Addendum No. 1

RE: Contract ID C203128

Durham, Wake Counties (U-4716A, B and C)

Clegg Passing Siding & Hopson Road Grade Separation and
Closing of At-Grade Railroad Crossings

PROJECT TITLE	U-4716 AC CLEGG PASSING SIDING & HOPSON RD. GRADE SEPARATION EROSION CONTROL PLAN MAIN STA 3335+00 TO 3363+00		
LOCATION	CP "NELSON" TO CP "CLEGG"	MILE POST	H-63.2 TO H-67.0
DGN BY	FJM	RAILROAD	NS / NCRR
DWN BY	RAC	VAL SEC	V-24 / 16-17
CHK BY	JAB	DATE	10/30/12
		SCALE	
		SHEET	OF

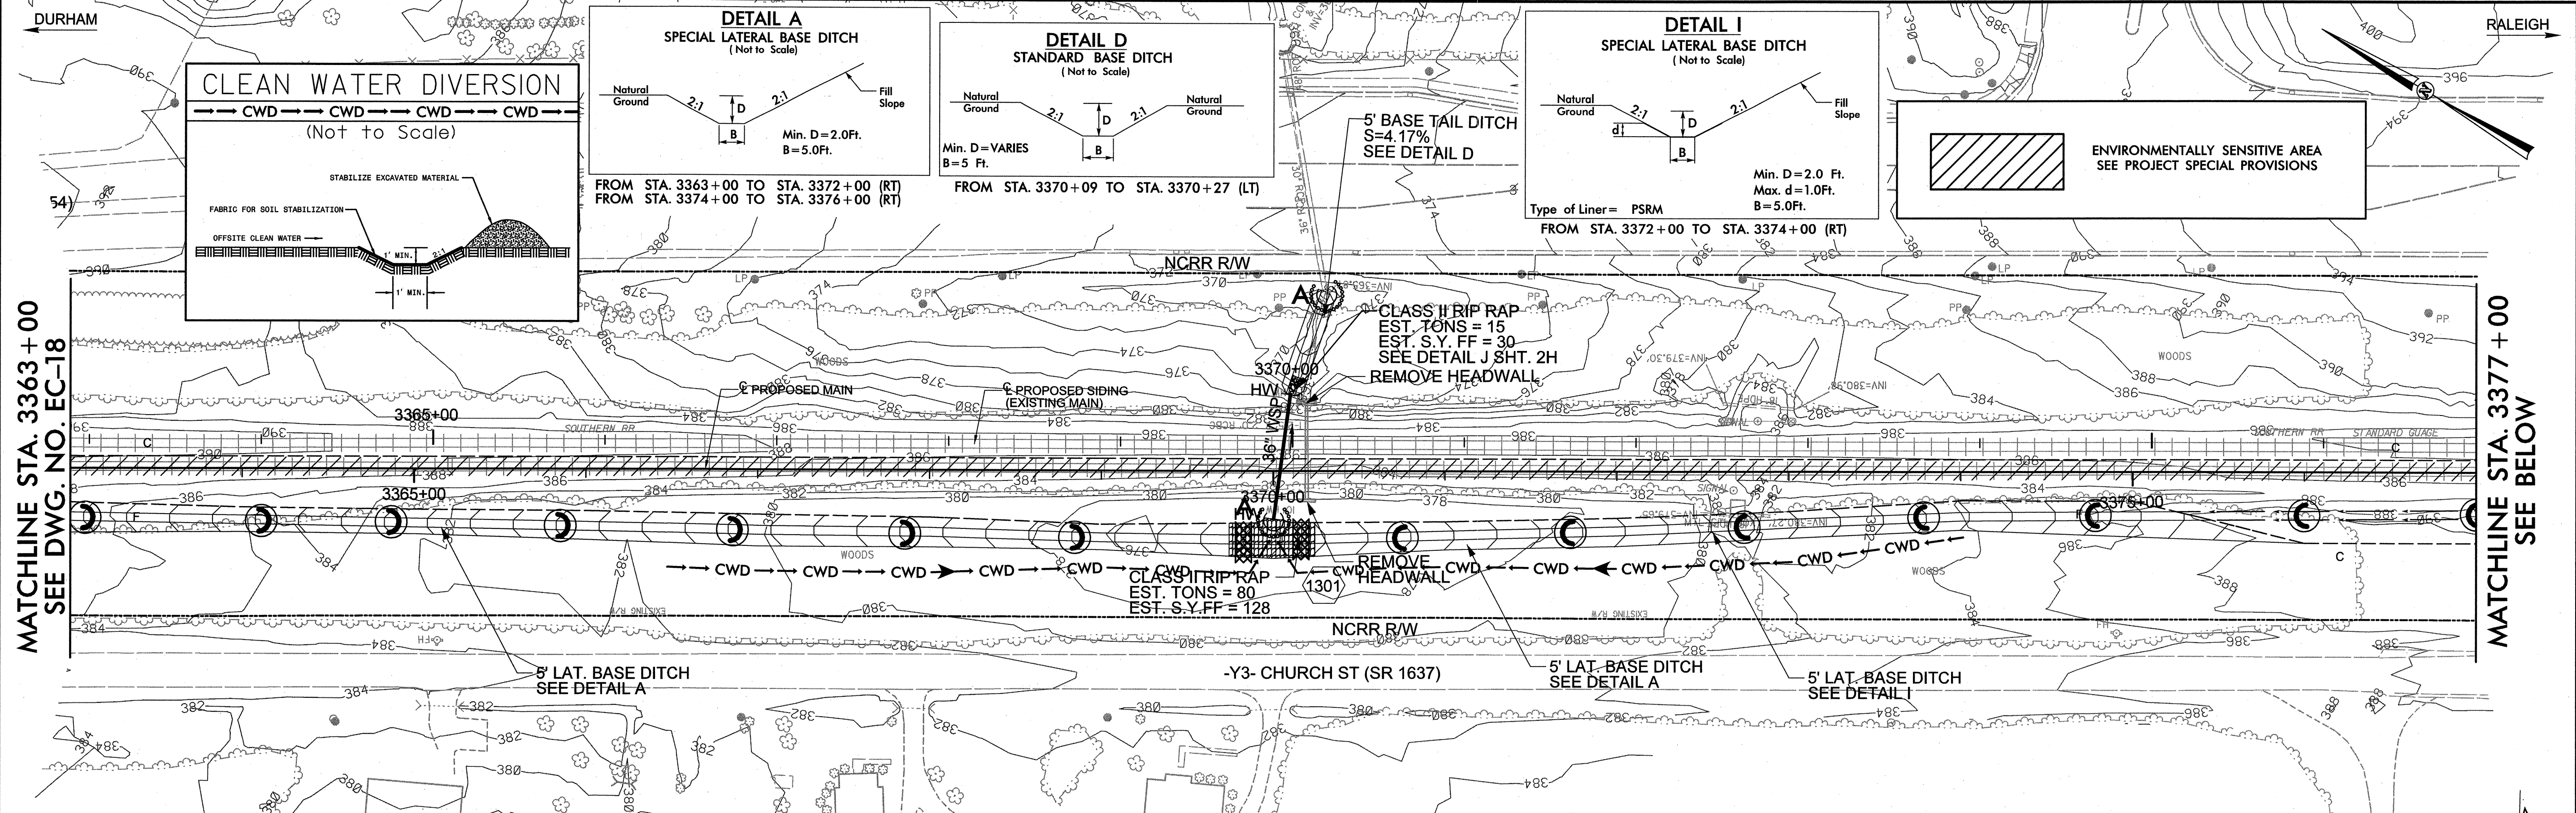
On Drawing No. EC-18, Detail "M" has been added. On Drawing EC-19 Detail "H" was changed to Detail "N". Please void Drawing Nos. EC-18 and EC-19 in your plans and staple the revised Drawing Nos. EC-18 and EC-19 thereto.
